Address: 4, Belton Grove, Huddersfield, HD3 3RF

Application number: 2025/93487	
What is the application for?:	Erection of two storey and single storey side extensions with rear dormer and as
Address of the site or building:	2, Belton Grove, Birchencliffe, Huddersfield, HD3 3RF
Postcode:	HD3 3RF

Rear Elevation 1.100

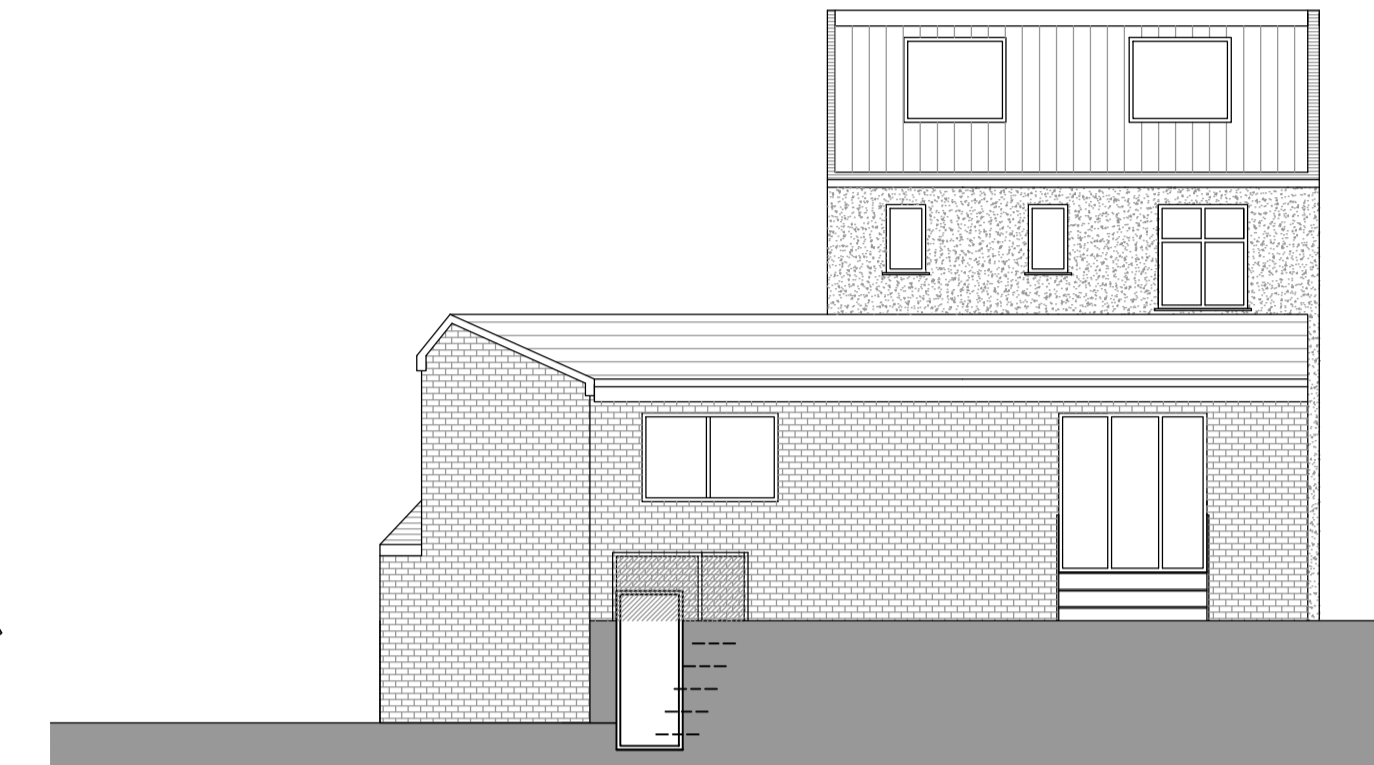
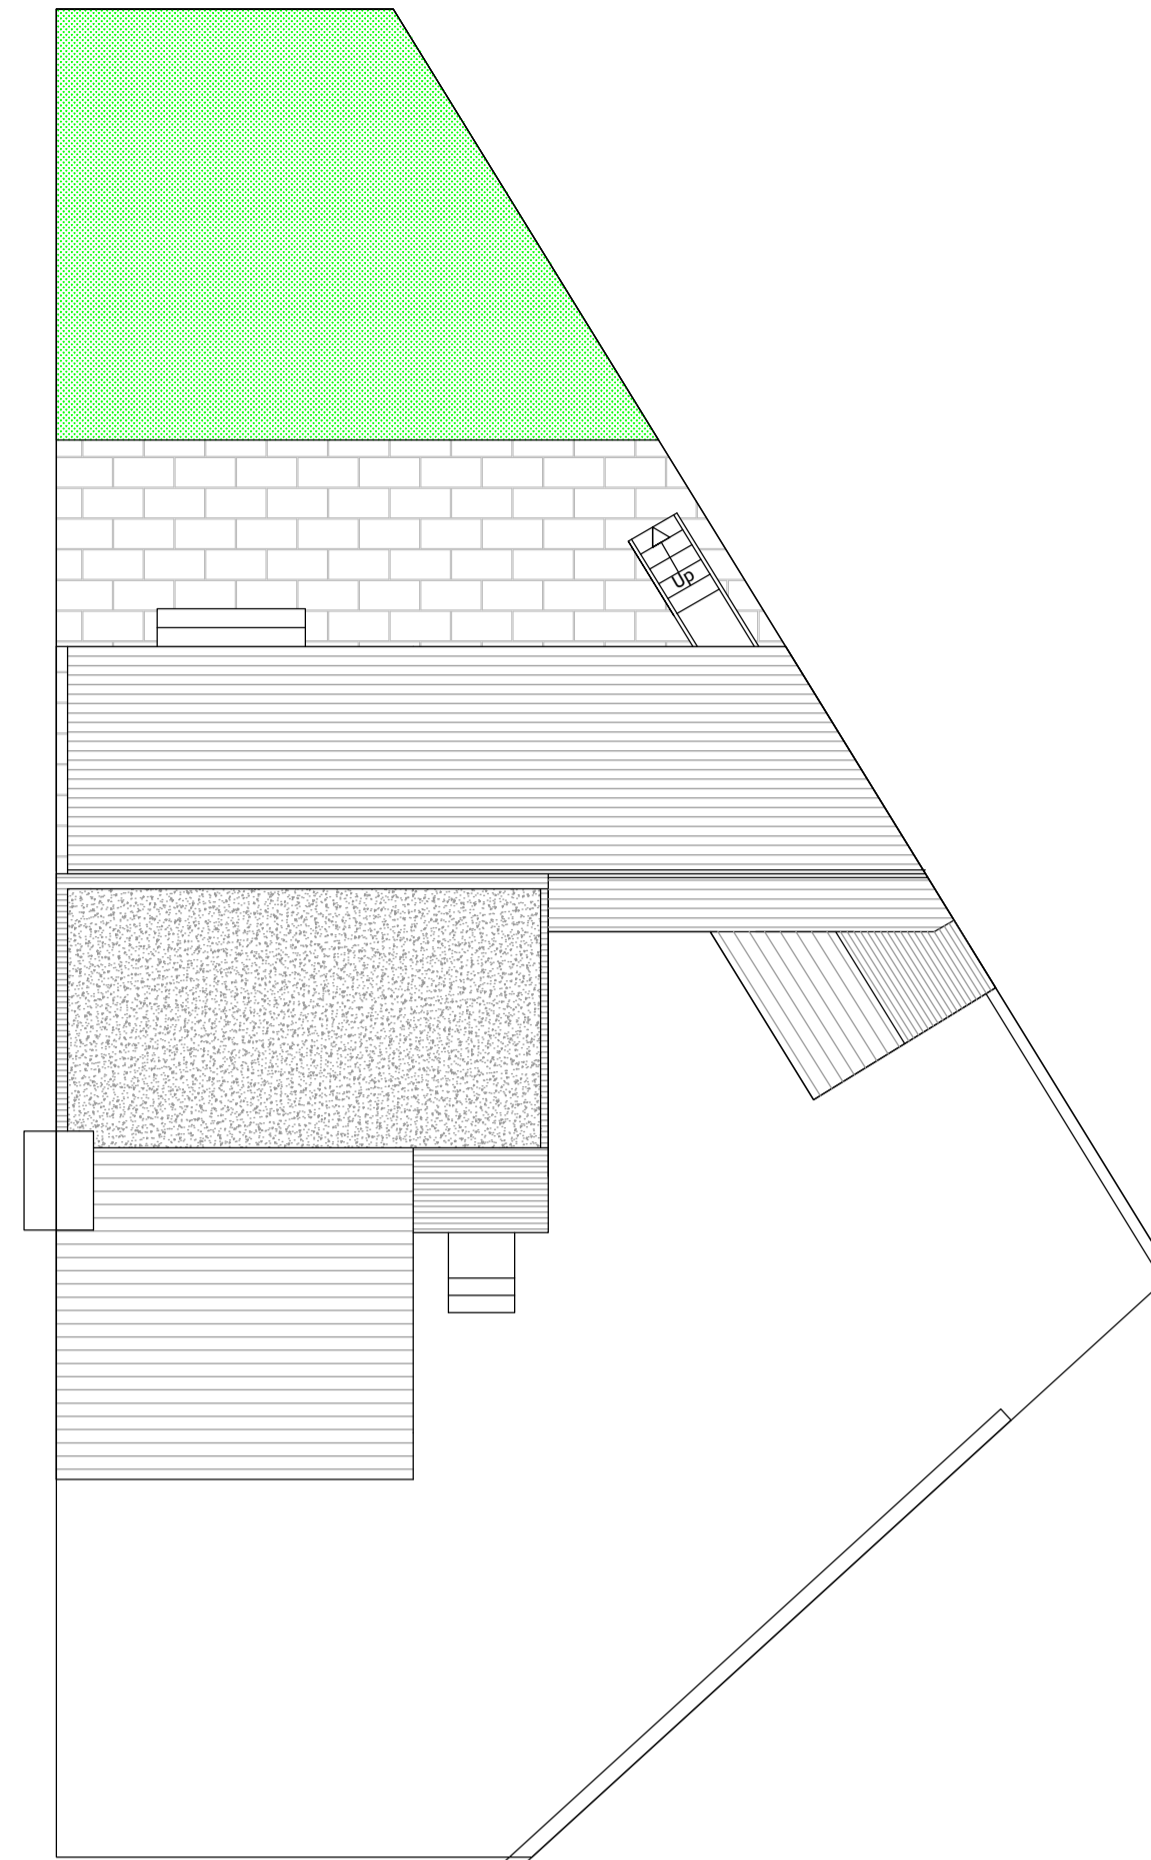
Type of comment: An objection	
Do you wish your comments to be published on the website anonymously?	No
<p>Hello,</p> <p>I wish to formally object to the above planning application for a dormer extension at my neighbours address, 2 Belton Grove HD3 3RF.</p> <p>The submitted drawings indicate that the proposed dormer extends directly to the shared boundary line with my property at 4 Belton Grove, HD3 3RF.</p> <p>I am concerned that this would have a significant and unreasonable impact on my property and future development potential.</p> <p>I am currently in the process of preparing a planning application for a dormer extension to my own property, with my architect finalising the submission.</p> <p>The proposed development, as shown, would prejudice and restrict my ability to reasonably develop my property in a similar manner, which I believe is contrary to the principle of fair and balanced development between neighbouring properties.</p> <p>I respectfully request that the Local Planning Authority gives due consideration to the impact of this proposal on neighbouring properties, including the effect on my ability to carry out reasonable and comparable development.</p> <p>I would ask that the application be refused or amended to provide an appropriate set back from the boundary to avoid adverse impacts.</p> <p>Thank you for taking my comments into consideration. Yours faithfully,</p>
